Our reference: TPO 2022/015  
Date: 26/04/2022

**Borough of Rossendale – Tree Preservation Order at Aldenbrook, Sunny Bank Road, Helmshore, Rossendale. BB4 4FE**

**Proposal: Fell three Ash (T53, T59 and T62) and one Horse Chestnut (T55).**

TREE IDENTIFICATION PLAN
AREA NEAR GAS GOVERNOR.

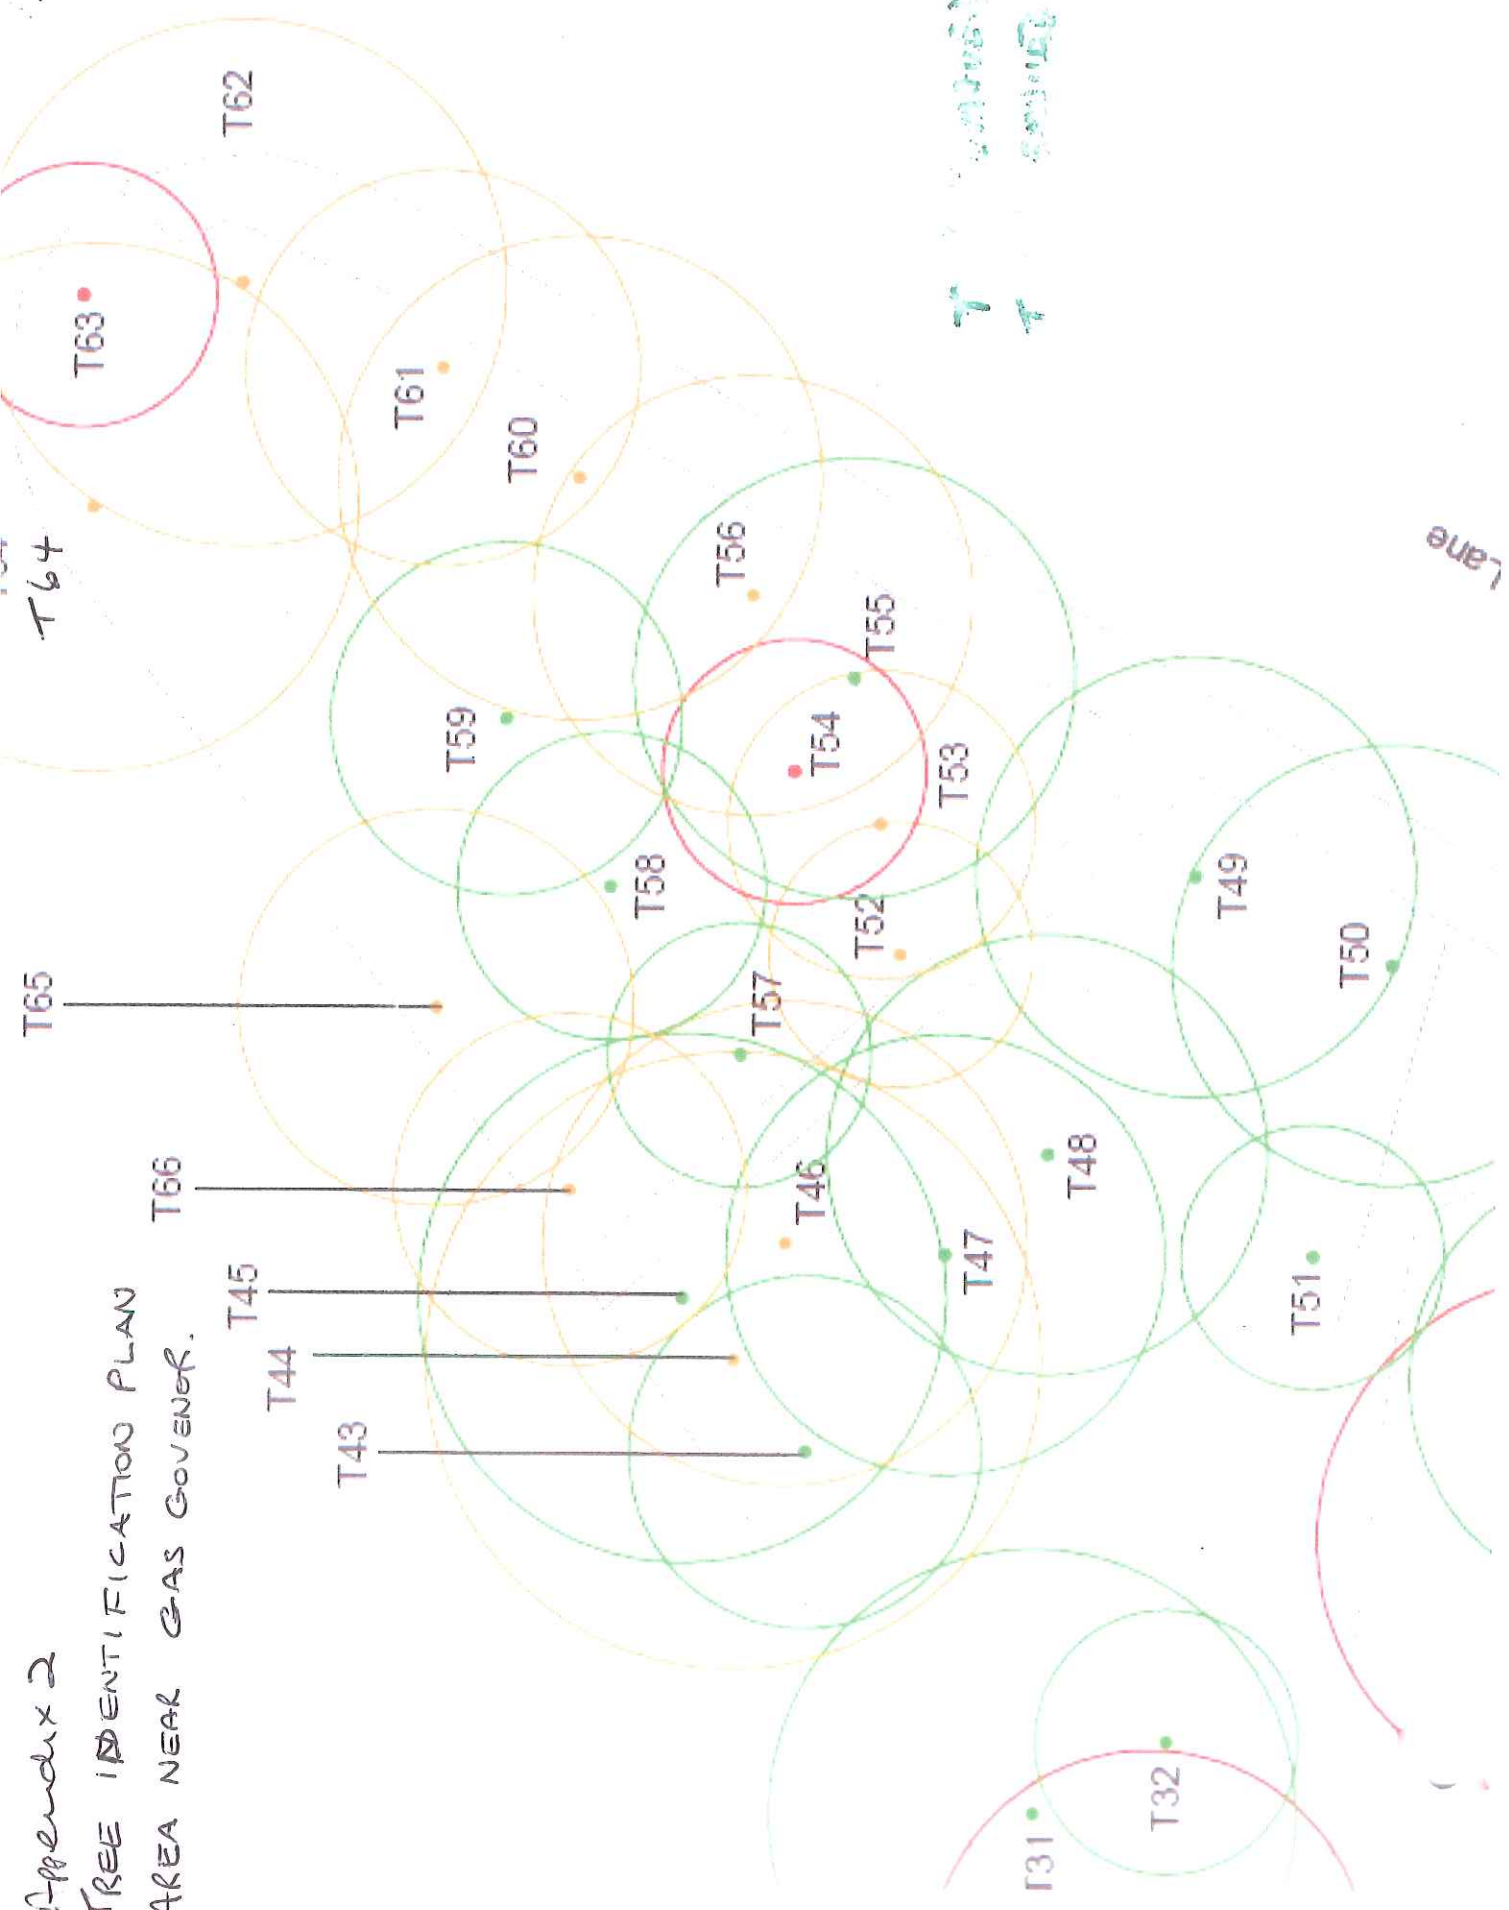
**Assessment:** Amongst the group of trees on the area of land there are three Ash, one large and mature the others, smaller and semi-mature but drawn tall due to competition. The largest is T62 and is on the apex of the area of land at the junction between Free Lane (B6214) and Woodbank. The smaller two are T53 and T59 and are more towards the centre of the land. All three trees, however, have a road within their falling arc and T62 has large branches overhanging the roads and all three are exhibiting significant crown die-back which is probably due to Chalara Ash die-back.

Advice from the Forestry Commission and Arboricultural Association normally suggests that trees should be pruned and monitored as they may prove to be immune/resistant. However, given the extent of die-back and the proximity of road and other targets, felling on safety grounds is the only reasonable course of action.

Horse Chestnut T55 is reported to be affected by Honey Fungus but, upon inspection, I could not find evidence of that. I did, however, see an area of Bacterial Wet Wood slime flux at about one metre above ground level on the north side of the trunk. Infection by this disease does not warrant felling as trees can recover given the opportunity and the buds appeared to all be swelling and opening satisfactorily. I would therefore suggest that this tree is monitored.

I did notice that a separate Horse Chestnut (T61) has a significant wound on the south side of the trunk extending from ground level to almost three metres up the trunk. The wound is occluding and appears to be dry and not decaying but it should be monitored. No application for work on this tree has been submitted at this time.

**Decision:** Consent: Fell three Ash T53, T59 and T62.

Refuse: Fell one Horse Chestnut T55.
